CITY OF ALBUQUERQUE

RE: **Carmel Ridge Subdivision**
9154 Carmel Ave. NE
Engineer's Certification – Conditional Approval
Engineer's Stamp Date: 3/1/17
Certification Dated: 6/20/18
Hydrology File: C20D075

DRAINAGE AND TRANSPORTATION INFORMATION SHEET (REV 3/2018)

BEING A REPLAT OF LOT 29, BLOCK 3, UNIT 3, TRACT 2, NAA  
GRADING & DRAINAGE PLAN

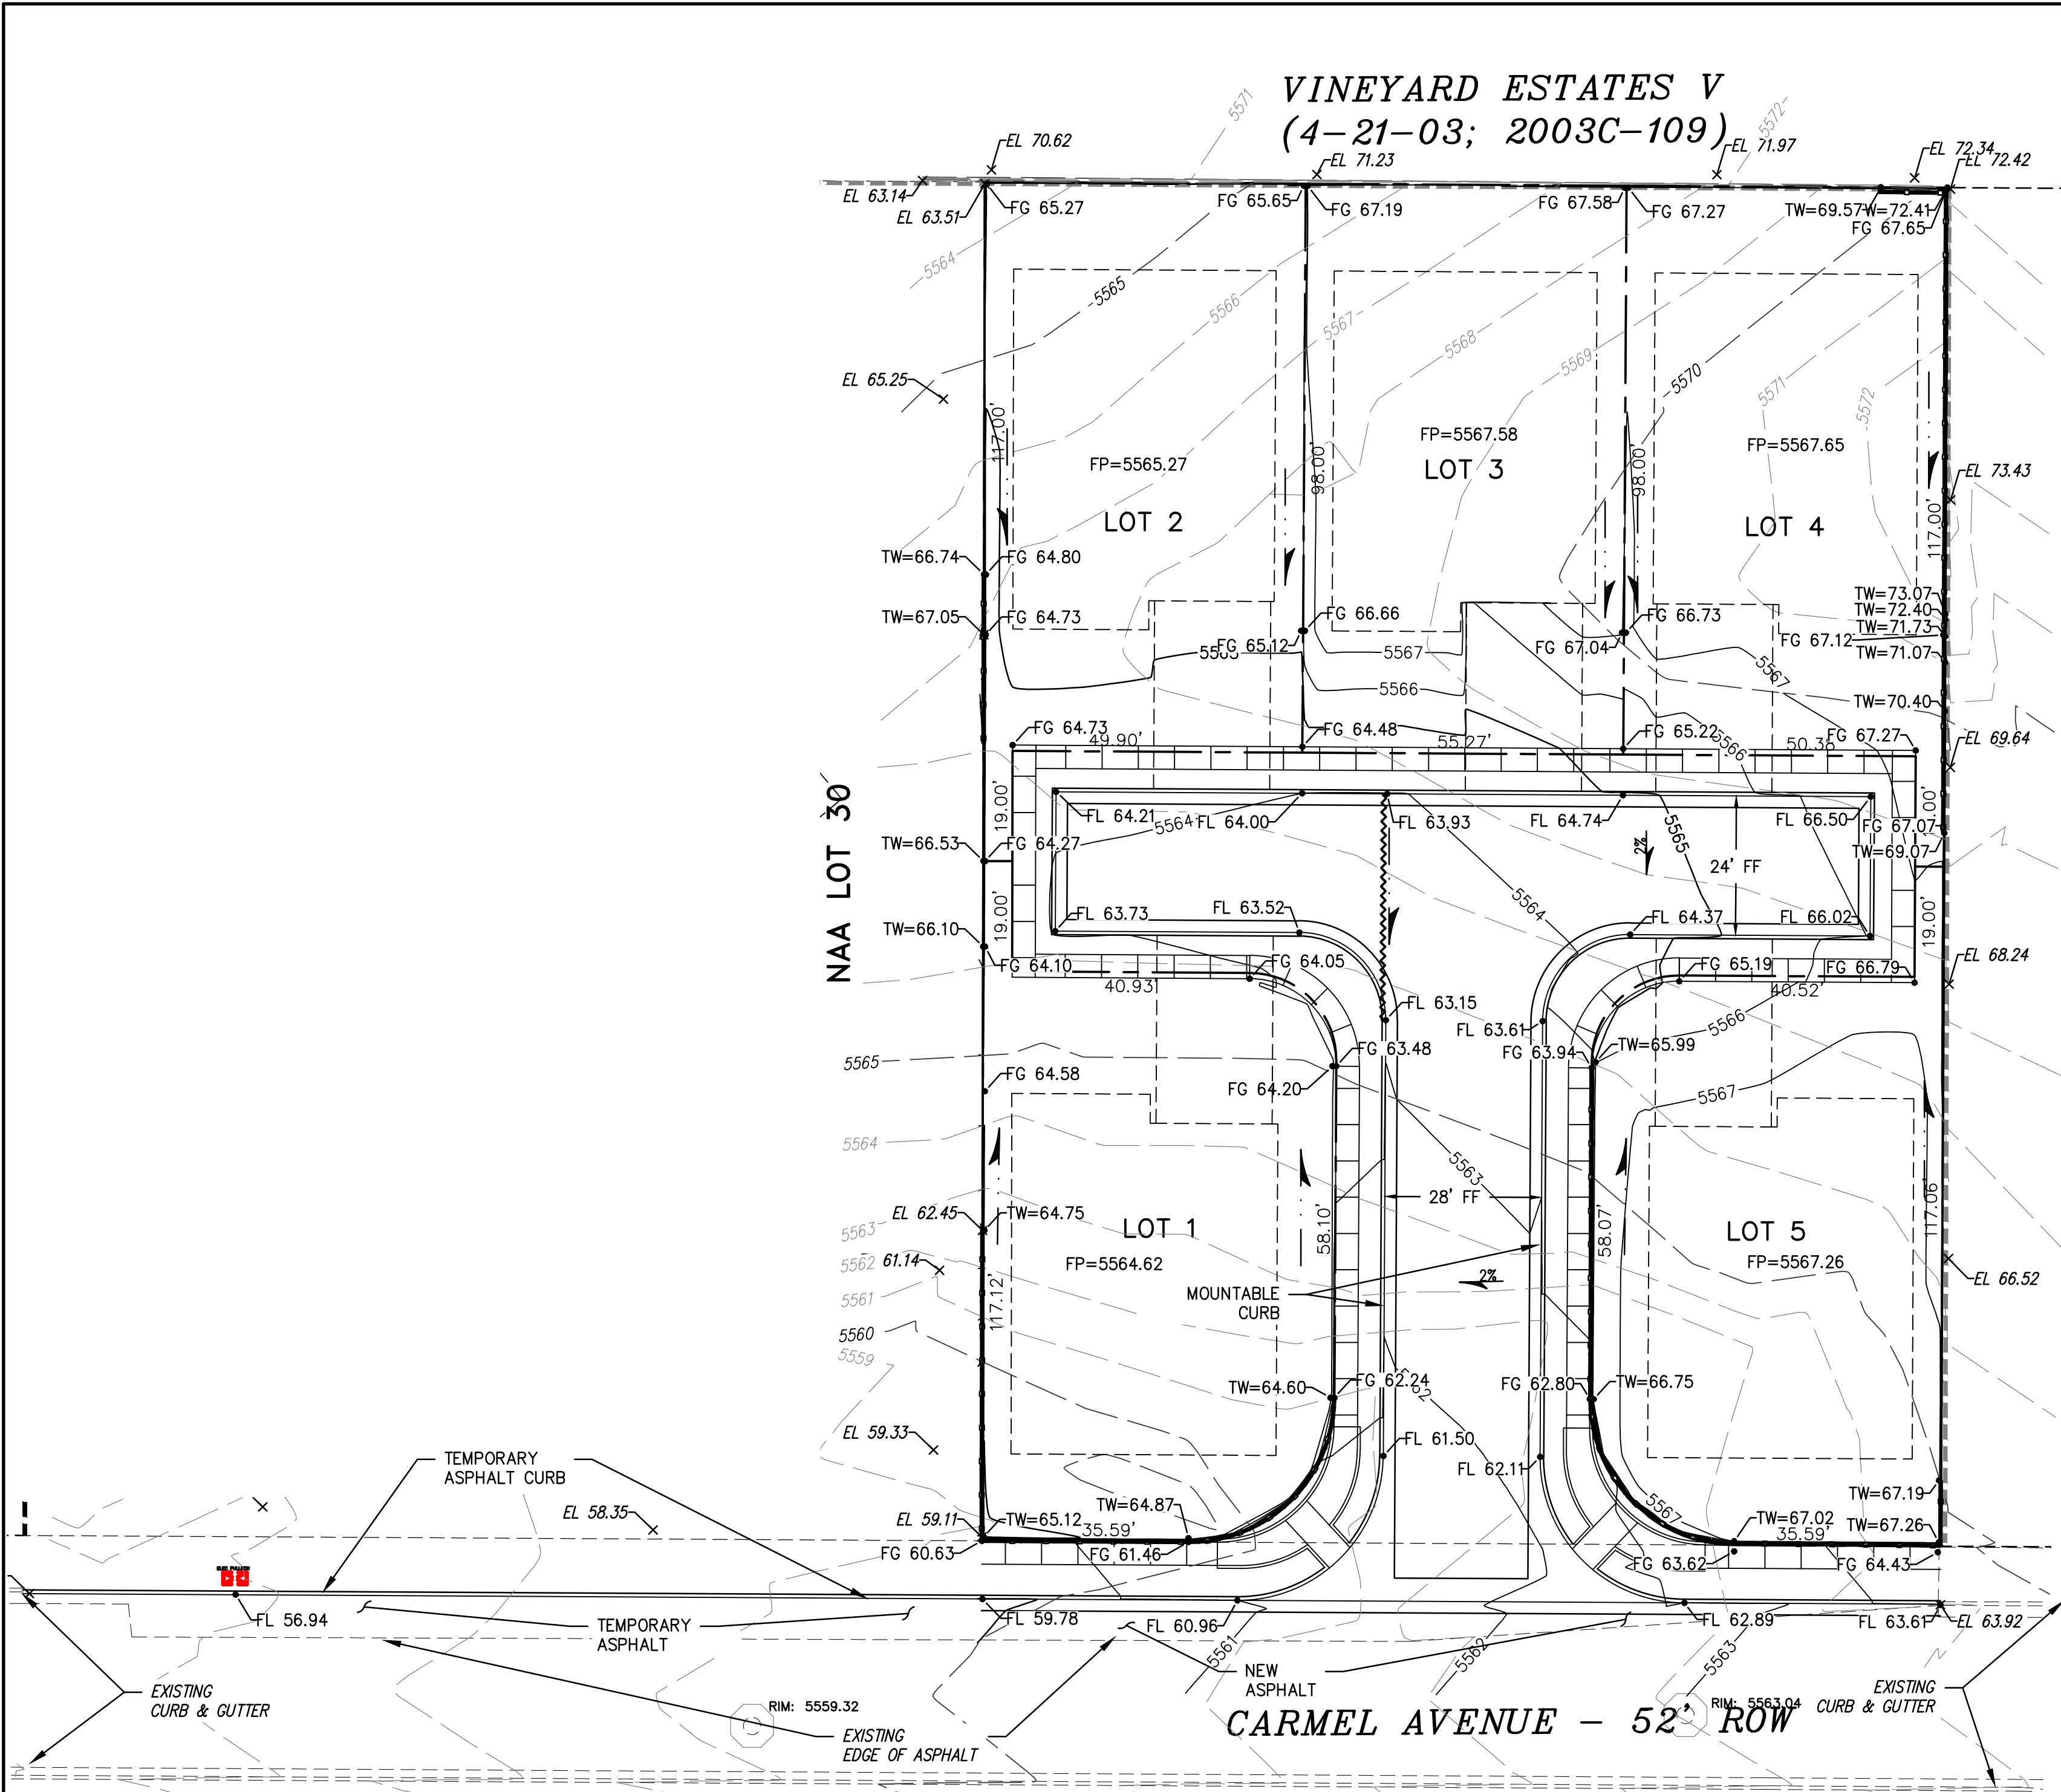
1. Either lot 2 and/or 3 stating that the cross lot drainage has been corrected
2. Either lot 4 and/or 5 showing extensive as-built elevations on both sides of the retaining wall on the east side of the site, to include any necessary modifications to the approved G&D as necessary to resolve the complaints from the neighbors to the east.
